From: chris barrow [redacted@uk]
Sent: 25 June 2015 13:13
To: Janice Chapman
Subject: RE: FP/85/15/HH - Two storey side extension at 18 Outerwyke Gardens, Felpham

Subject: FP/85/15/HH - Two storey side extension at 18 Outerwyke Gardens, Felpham

SITE LOCATION & BLOCK PLANS			
Scale	1:1250 - 1:500	Drawn By	ACB
Date	27/03/2015	Checked	CB
Drawing Number	1202 - 01

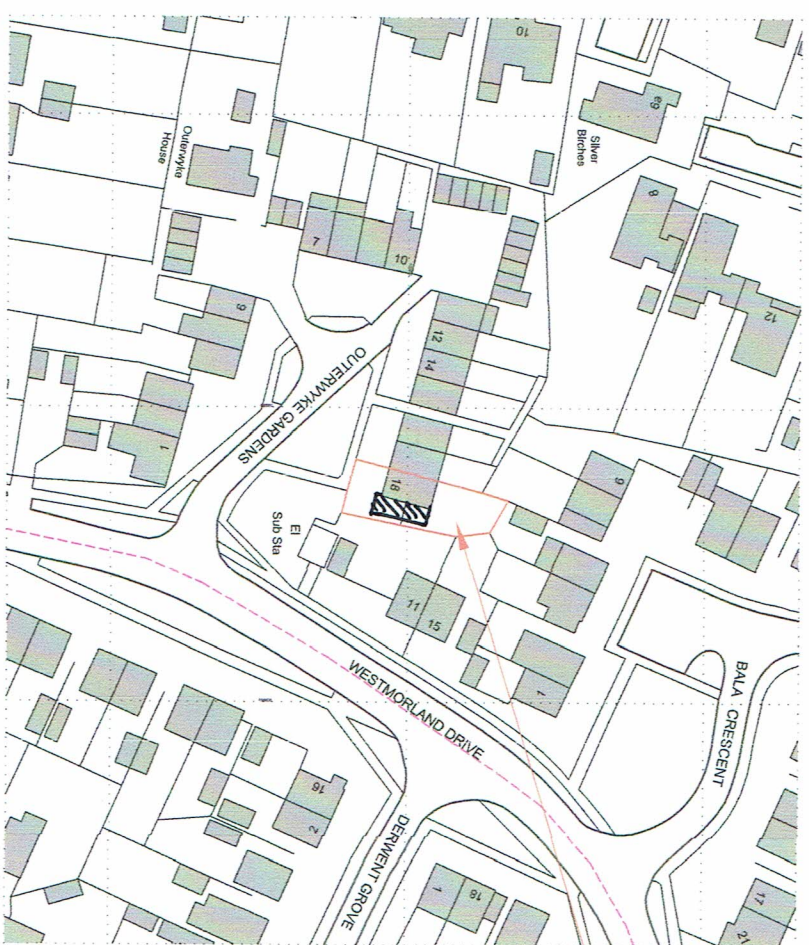
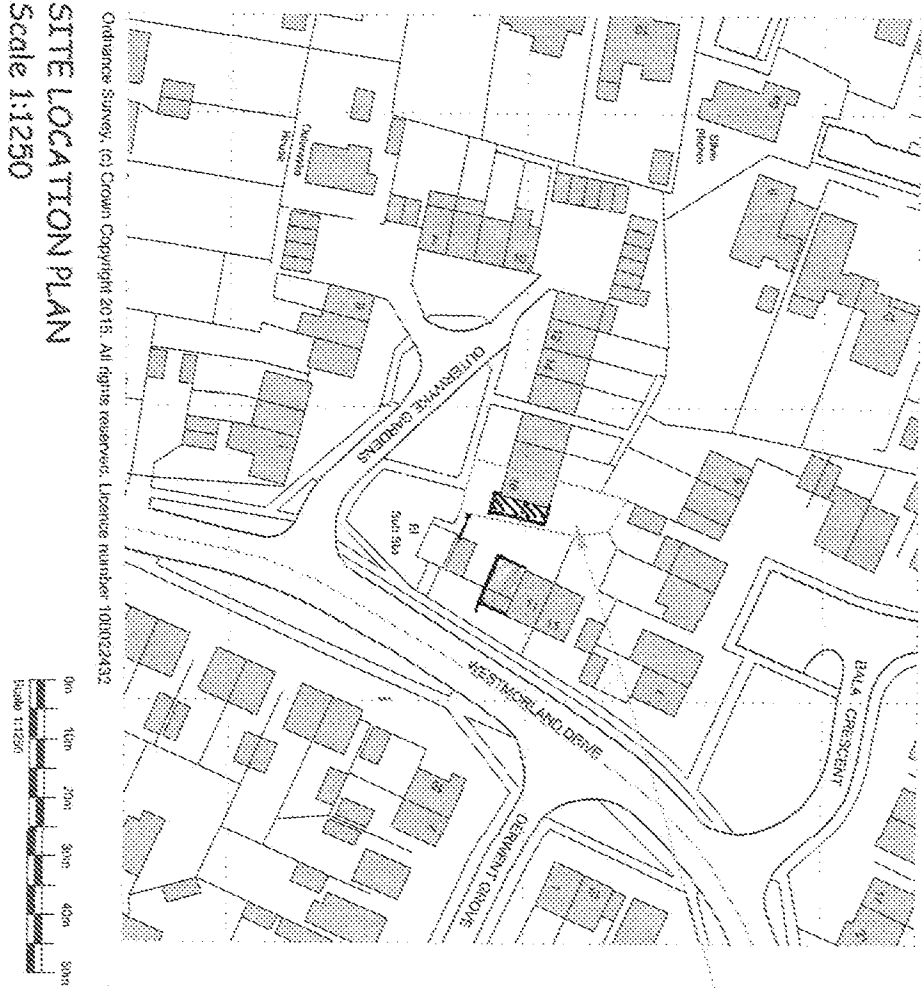
From a site inspection it was noted that a new dwelling has been constructed to the east of the site adjacent to No 11 Westmorland Drive. Please can you submit an amended Block Plan to show this dwelling.

Please see attached amended block plan if not received before.
